**PLANNING ACT 2008**  
**Morecambe Offshore Windfarm Generation Assets Development Consent Order**  
**Application**

**Planning Inspectorate Reference: EN010121**

**Summary of Relevant Representation of Spirit Energy Production UK Limited in Response  
to the S56 Notice**

**15 October 2024**

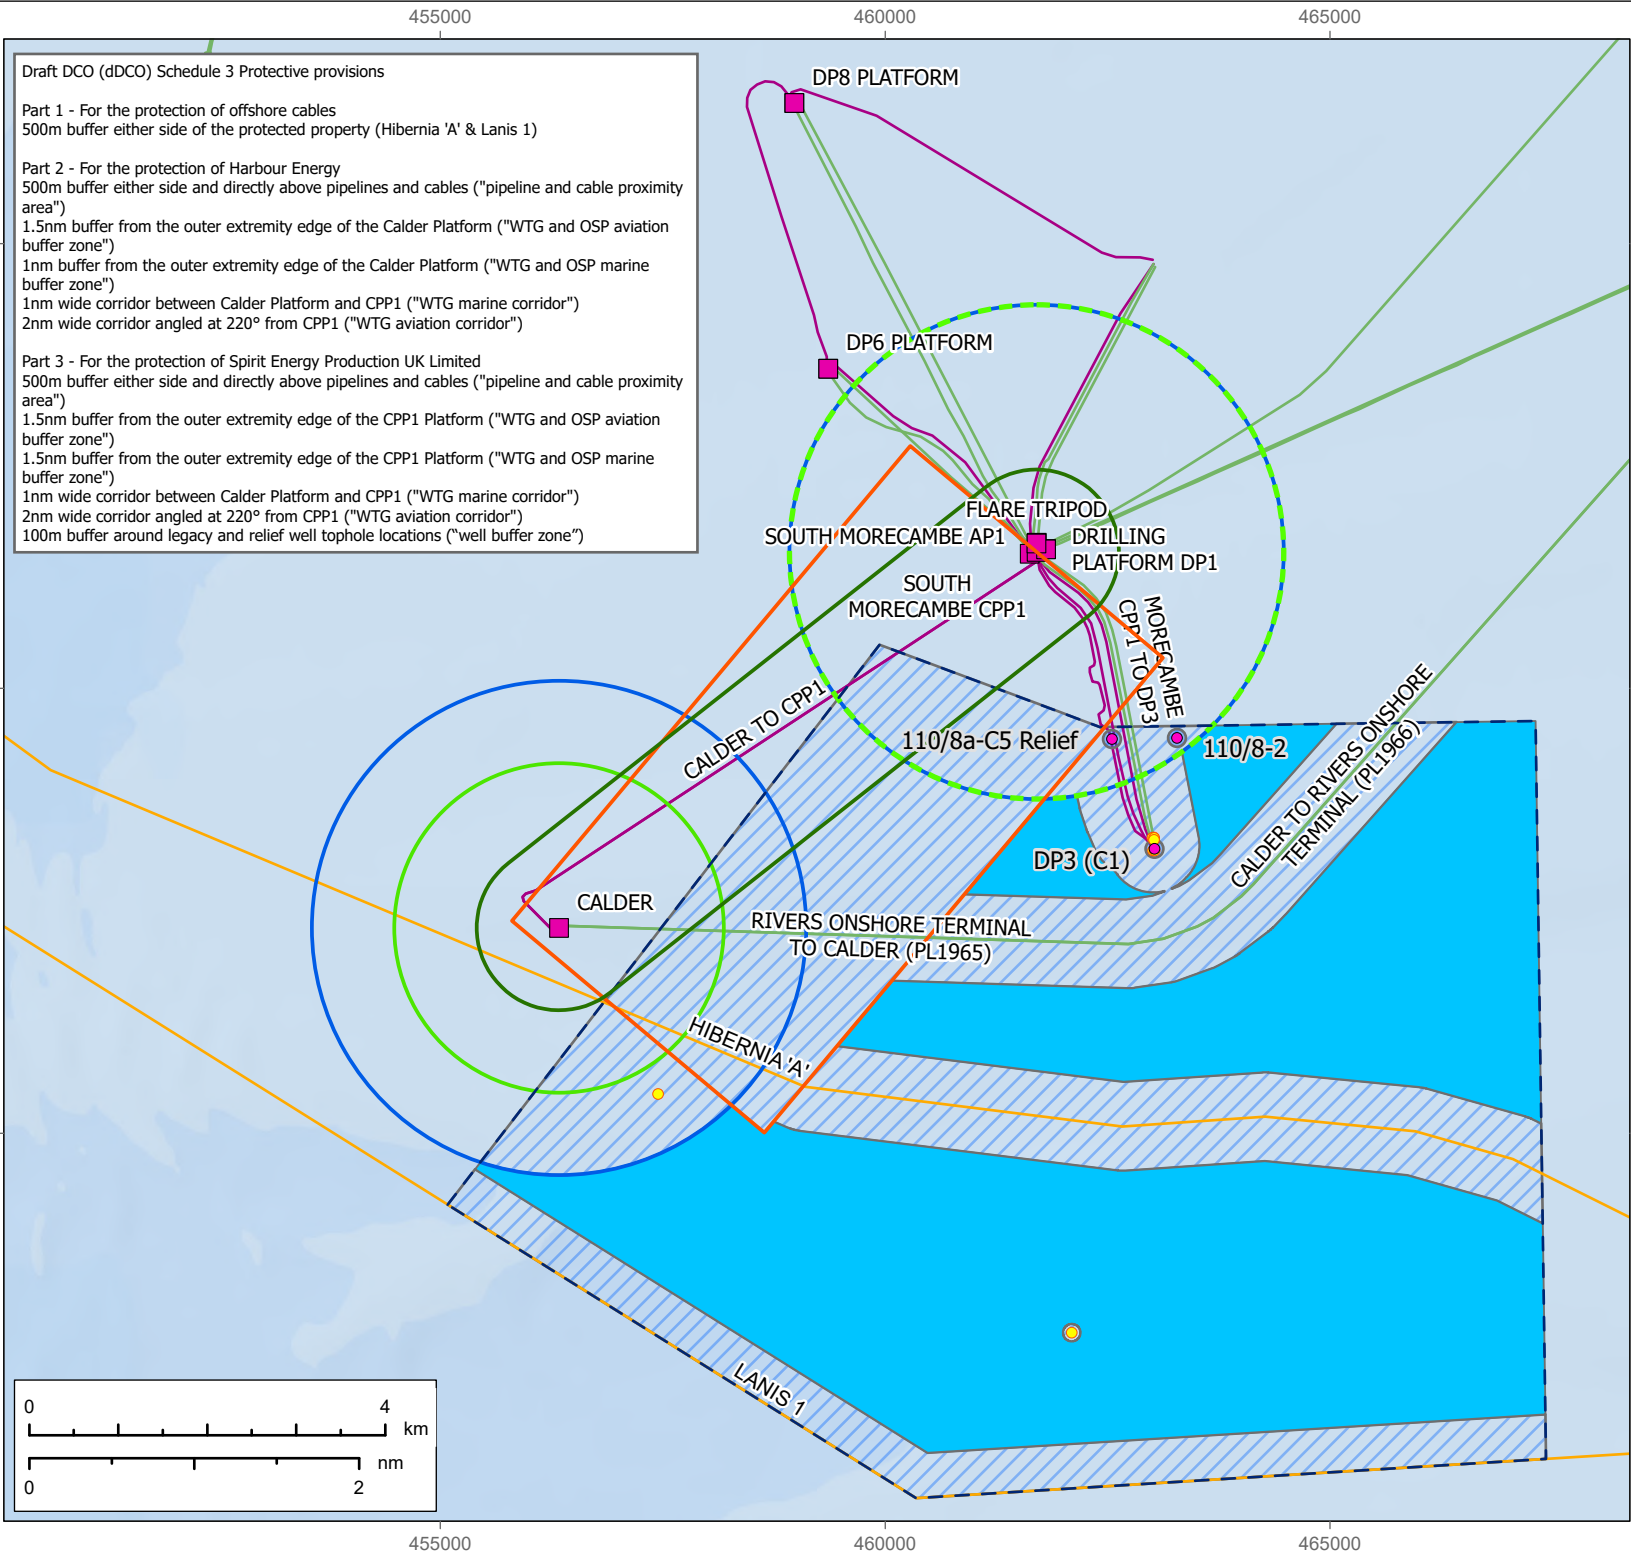
- 5.4 Designated access paths and exclusion areas in addition to the 500m exclusion zone around each platform will be required.
- 5.5 The protective provisions only secures a 1.5nm buffer between the "active" AP-1, DP-1 and Calder "heli-decks". A 1.5nm marine buffer zone must therefore be secured independently of any corresponding aviation related buffer zone.

9. **Protective Provisions**
- 9.1 The protective provisions as proposed in Part 3, Schedule 3 of the dDCO are inadequate and do not serve to safeguard Spirit's assets and operations.
